Recommendation Report for Planning Permission for Works or Extension to a Dwelling

REF NO: AL/102/25/HH

LOCATION: 26 St Richards Road
Westergate
Aldingbourne
PO20 3RD

PROPOSAL: Hip to gable loft conversion with side dormer.

PROPOSED FLOOR PLANS, ELEVATIONS,  
 ROOF PLAN & SECTIONS  
 26 St Richards Road  
 Westergate, Aldingbourne  
 West Sussex  
 PO20 3RD

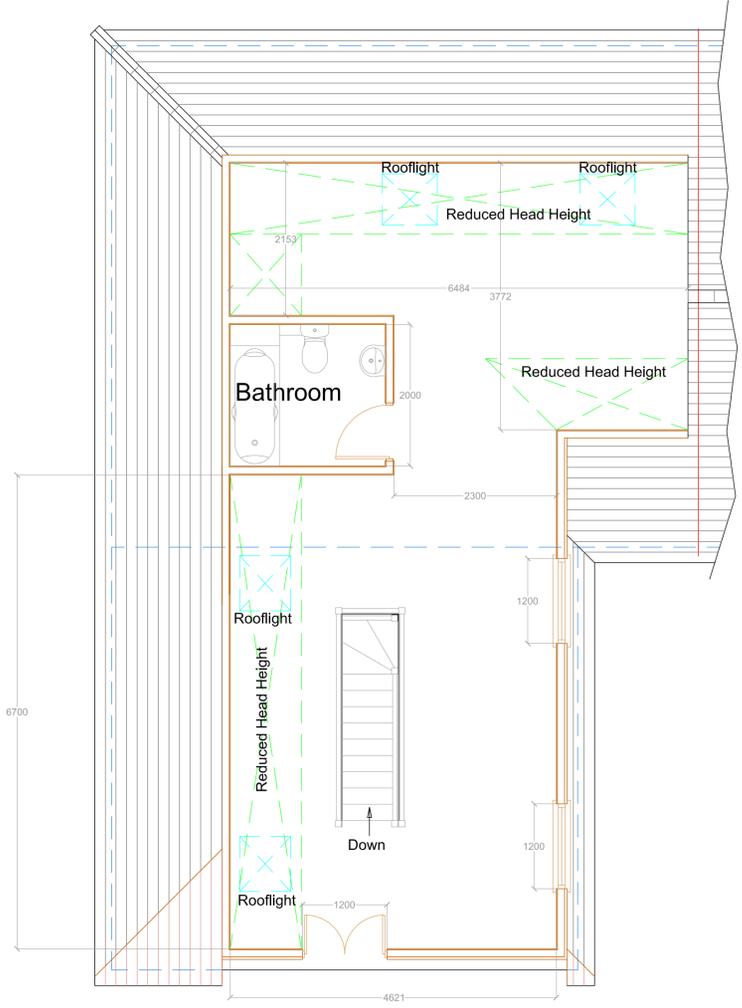
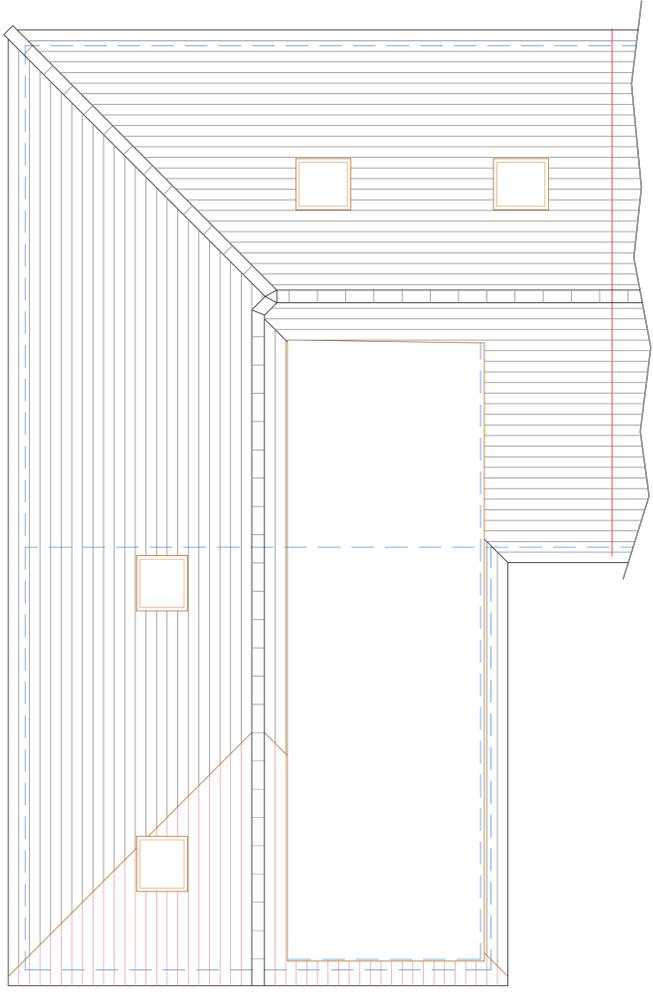
To facilitate the proposed loft conversion, a hip to gable roof extension is proposed. The ridge line of the host dwelling would be extended to the rear (west), creating a gable end to the rear elevation. It is noted that the hip to gable roof extension would unbalance this pair of semi-detached bungalows, however an existing rear extension already plays some part in this. The roof extension would have a volume of 14.05m³ and therefore it is noted that the extension could be constructed under permitted development. The extension respects the original roof ridge height, and it would not reduce the separation distance between the host dwelling and neighbouring properties. The roof extension would be sited to the rear therefore, the proposed hip to gable roof extension would not appear prominent or out of character within the street scene and would not result in harm to the character of the host dwelling.

The side dormer would have a flat roof form and would measure 8.7m wide, 2.6m deep and 2.5m high. It would be set down 0.4m from the main ridge of the dwelling and set in 0.4m from the flank elevations. The dormer is in partial conflict with the Arun Design Guide, which states that dormers should be minor incidents on the roof plane and incorporate pitched roofs in most cases, avoiding large box-shaped designs. However, as the dormer is to the rear of the property thus will not be visible from the public realm and is similar to that which could be constructed under permitted development. As such, the proposed rear dormer is acceptable in this instance.

Two rooflights are proposed to the front (east) elevation and two rooflights to the side (north) elevation of the dwelling. The rooflights would be proportionate in scale and number and would not result in any harm in this regard, furthermore there are several examples of front rooflights in the street scene.

Fenestration would be introduced into the first floor of the property as a result of the development. This includes two rooflights on the north (side) roof slope and two on the front (east) roof slope, and two windows on the side (south) elevation, which would be obscurely glazed and conditioned as such, given the proximity of the proposed southern facing windows to the adjoining neighbour to the south. On the rear elevation, a Juliet balcony is proposed. This will likely give rise to some increased overlooking of the

- 3 The windows within the southern elevation of the side dormer shall at all times be glazed with obscured glass and non-openable below 1.7m above finished floor level. This arrangement shall be permanently retained thereafter.
